Phone: 0300 123 6780
Email: developeras@lancashire.gov.uk
Your ref: 3/2026/0394
Our ref: 3/2026/0394/HDC/KW
Date: 25 August 2026

Location: Aisled Barn Downham Hall Pendle Road Downham BB7 4DN
Proposal: Planning permission for proposed conversion of existing barns and outbuildings to commercial office space, conference room, new internal entrance track with external wall amendments and associated works.
Grid Ref: 378461 444351

With regard to your further consultation letter, I have the following comments to make based on all the information provided by the applicant to date.

Figure 3.2: Site Access

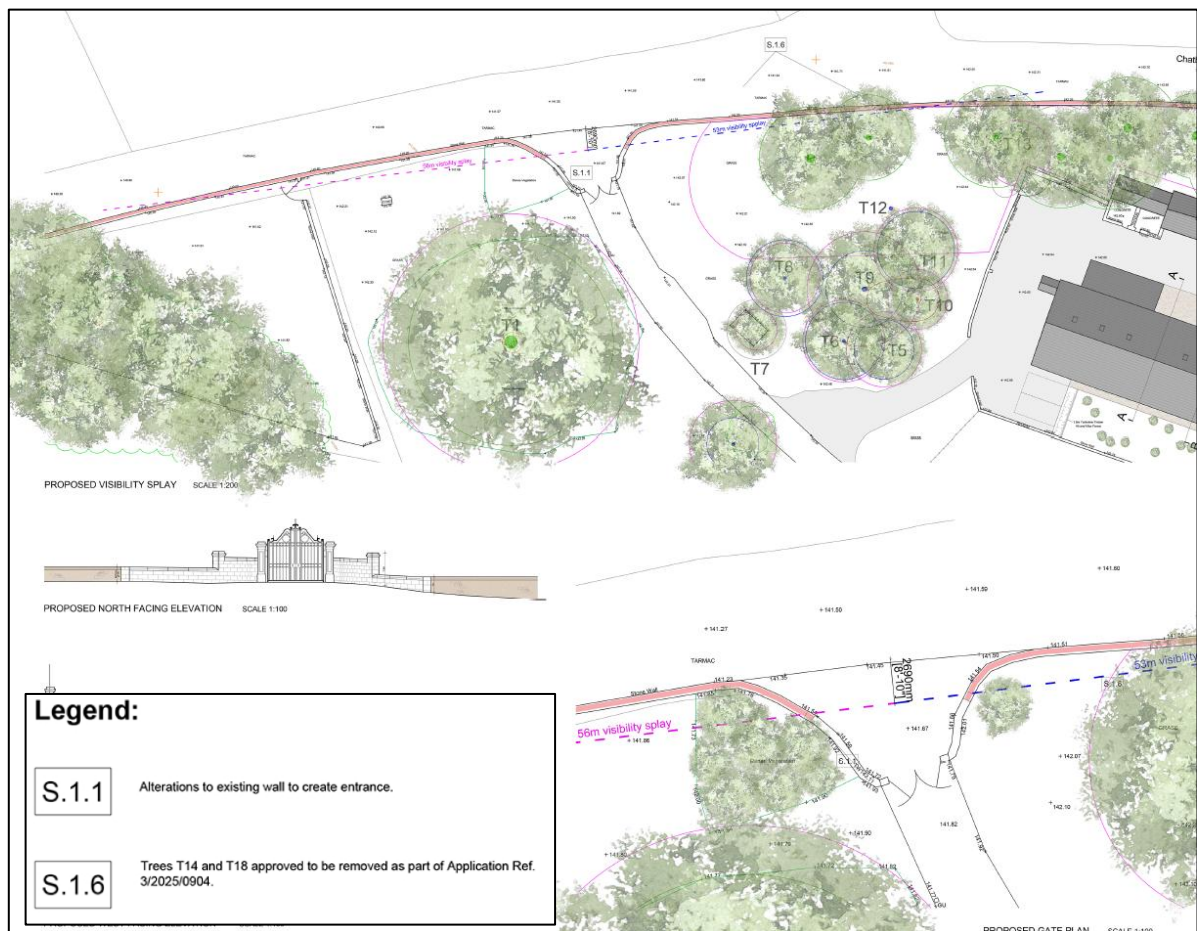
It is proposed to reduce the height of the boundary wall to maximise sightlines at the existing access. Sightlines of 2.4m x 56m to the West and 2.4m x 53m to the East, can be achieved, offset by 1m from the carriageway edge. The visibility splays are acceptable in this case and in line with Manual for Streets guidance. Where the visibility envelope falls across the existing boundary walls and/or any vegetation, these shall be reduced in height to no more than 0.9m above the carriageway level to maintain acceptable visibility. The access would also benefit from resurfacing in order to ensure debris is not dragged onto the highway, causing a skidding hazard.

2. No use hereby permitted shall commence until visibility splays 2.4 metres back from the centre line of the access and extending 56m to the West and 53m to the East, as shown on the approved plan, drawing number 6838-P10. Nothing shall be erected, retained, planted and / or allowed to grow at or above a height of 0.9 metres above the nearside carriageway level which would obstruct the visibility splay. The visibility splays shall be maintained free of obstruction at all times thereafter for the lifetime of the development.

**Figure 3.3: Indicative Vehicle Tracking - Access**

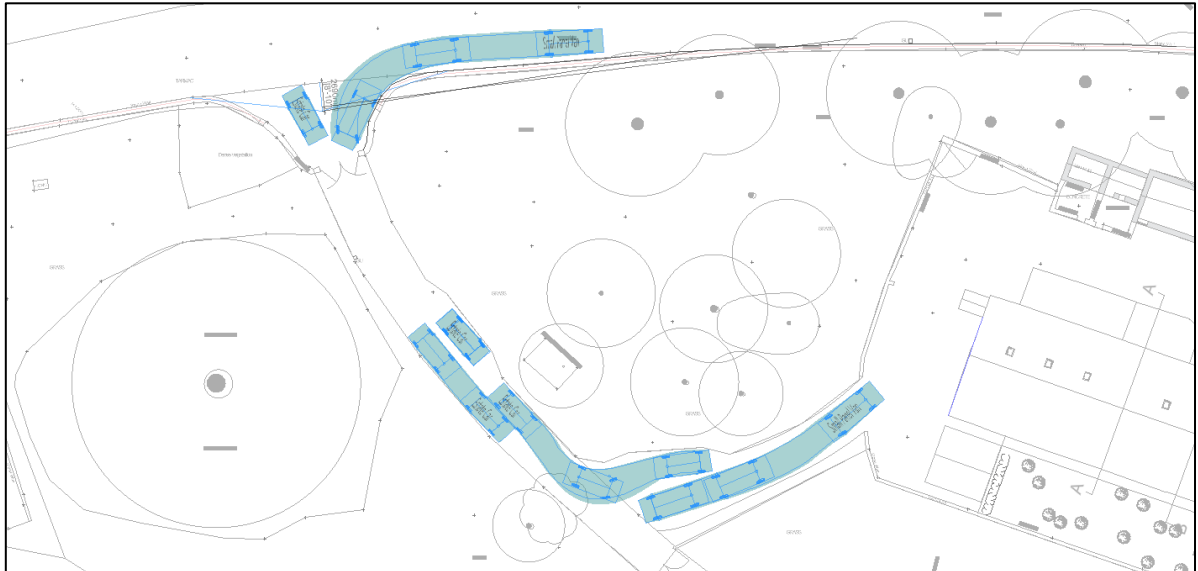
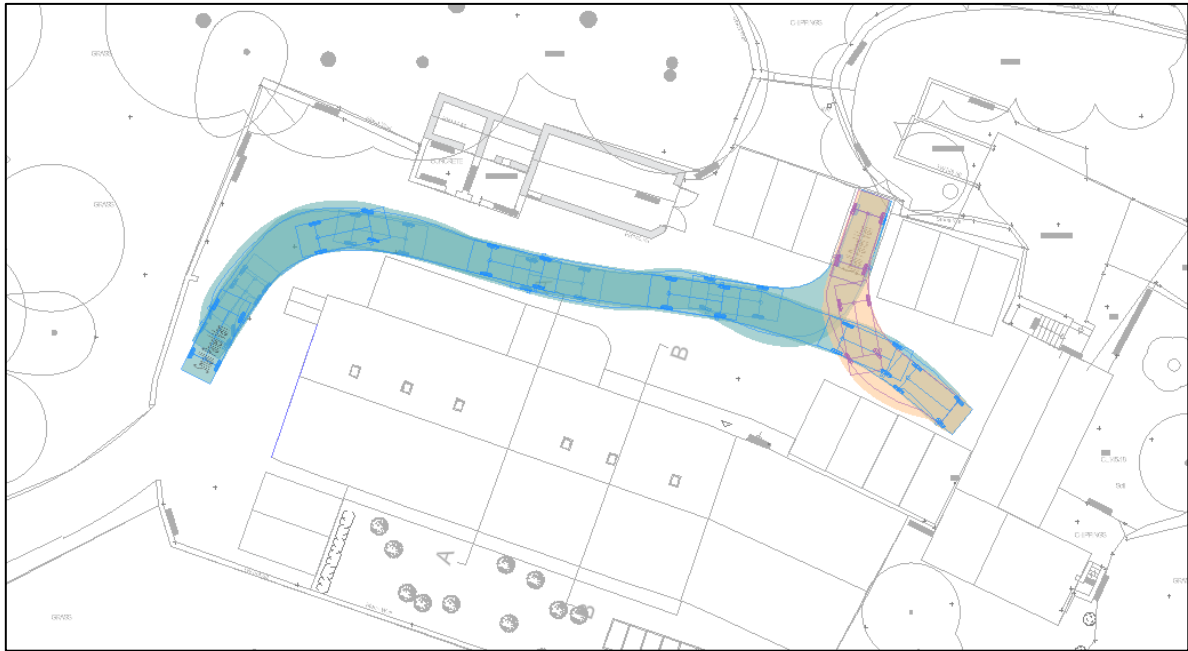
The applicant has also advised that deliveries to the site are anticipated to be in smaller light goods vehicles. It is anticipated that deliveries in these smaller vehicles will enter the site, park using the spaces available, complete their delivery, then exit in forward gear. The applicant has provided a swept path analysis assessment for a small van on Figure 3.3 and Figure 3.4 within the submitted Transport Technical Note.
